Planning Application No: 3/2023/0672

Proposal: Proposed demolition of conservatory, erection of single-storey extension, side porch, front porch and gates/railings to driveway.

Location: Black Hall, Garstang Road, Chipping PR3 2QJ

EXISTING ACCESS LAYOUT

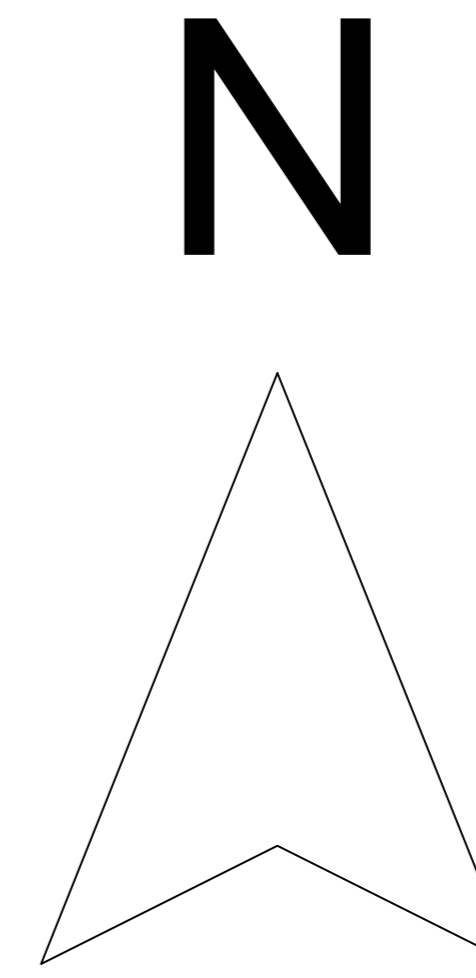
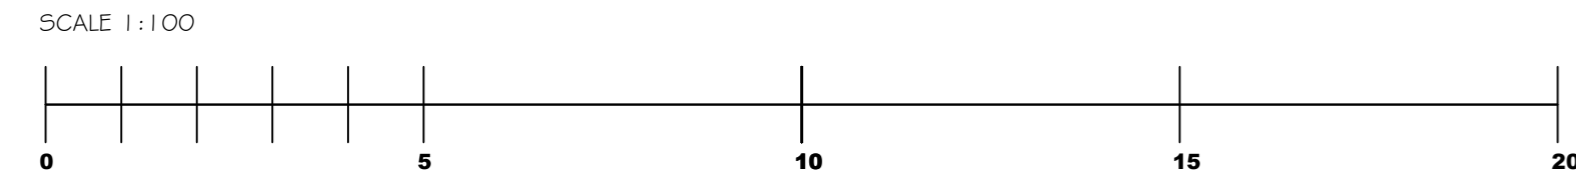
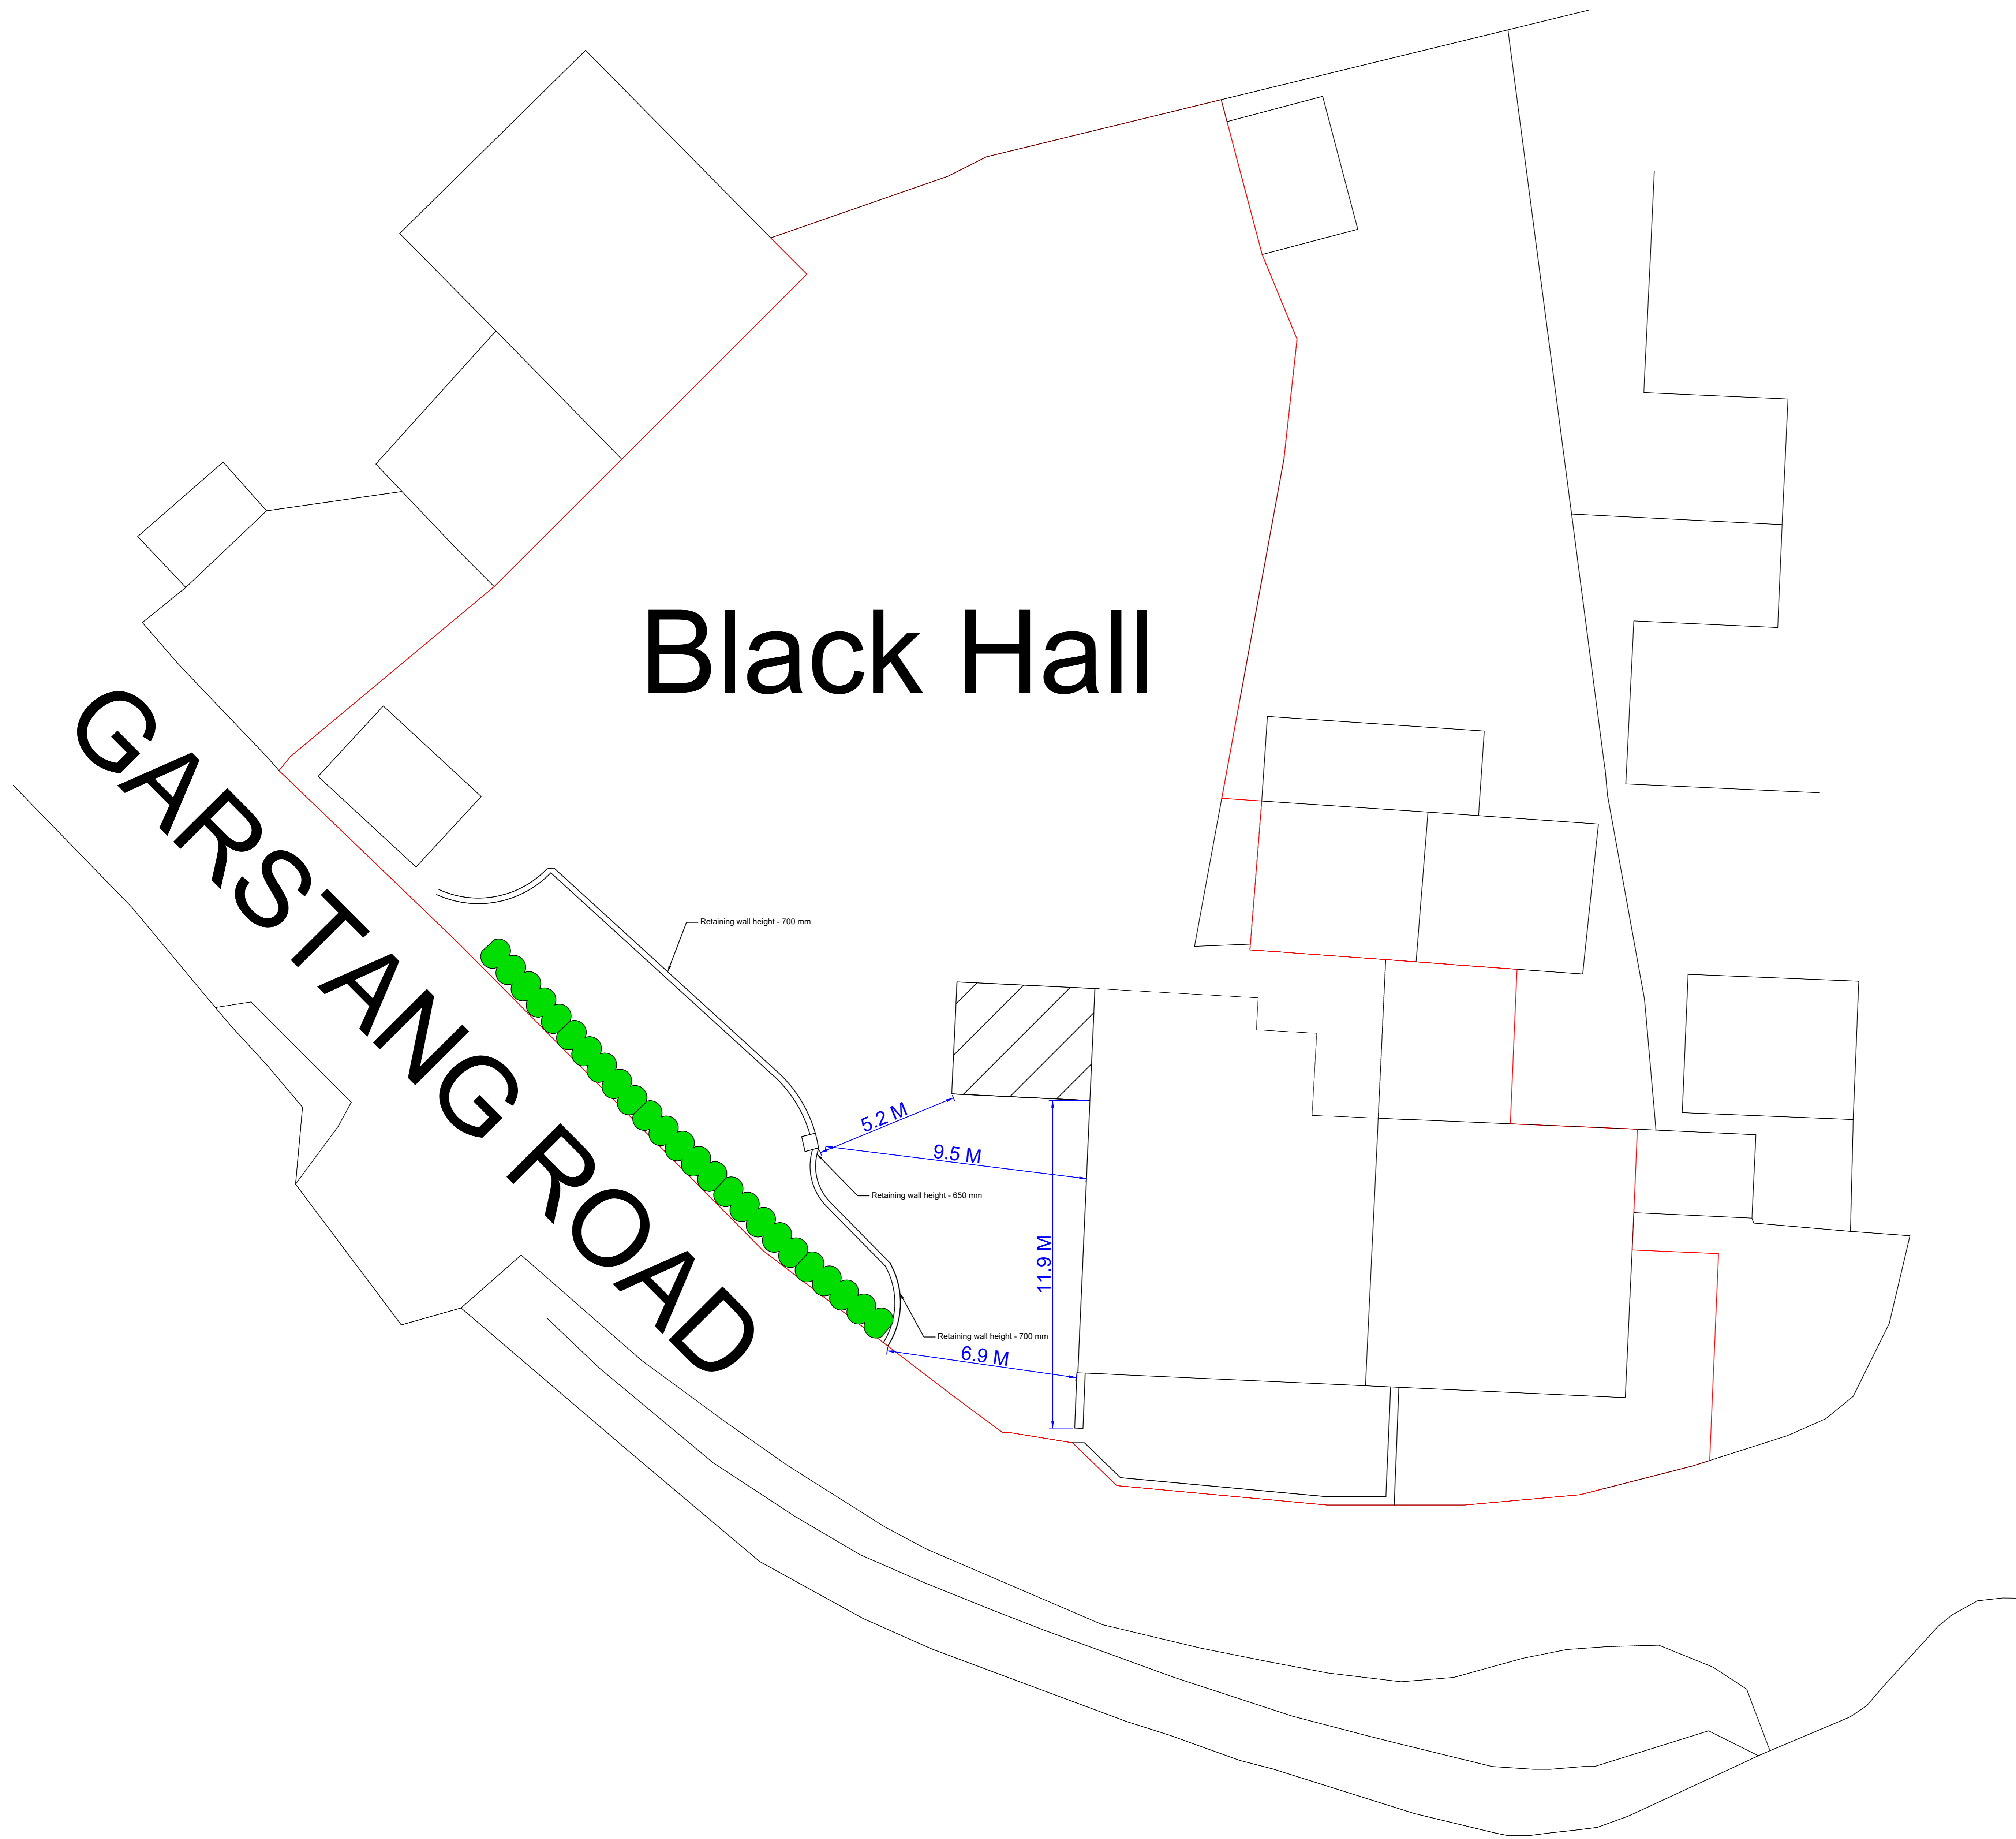
The site was visited on 19 September 2023 when it was noted that the vehicular access to the site has been amended at some point since 2009 without planning permission being granted or permission received from the highway authority.

The driveway/hardstanding will need surfacing in a bound porous material for a minimum distance of 5m into the site from the carriageway edge to prevent loose material from being carried onto the public highway. Surface water should also be drained to an internal outfall to prevent water from discharging onto the public highway. In addition the line of stone setts across the access would need raising so that there is a minimum 25mm upstand across the whole access as there is currently a low point causing surface water to collect and pond, which can pose a hazard to other highway users.

Prior to first use of the approved development, the hardstanding shall be surfaced in a bound porous material for a minimum distance of 5m into the site from the carriageway edge, the stone setts across the access lifted and re-laid and surface water from the hardstanding drained to an internal outfall in accordance with a scheme to be approved by the Local Planning Authority in consultation with the Highway Authority. Reason: In the interest of highway safety.
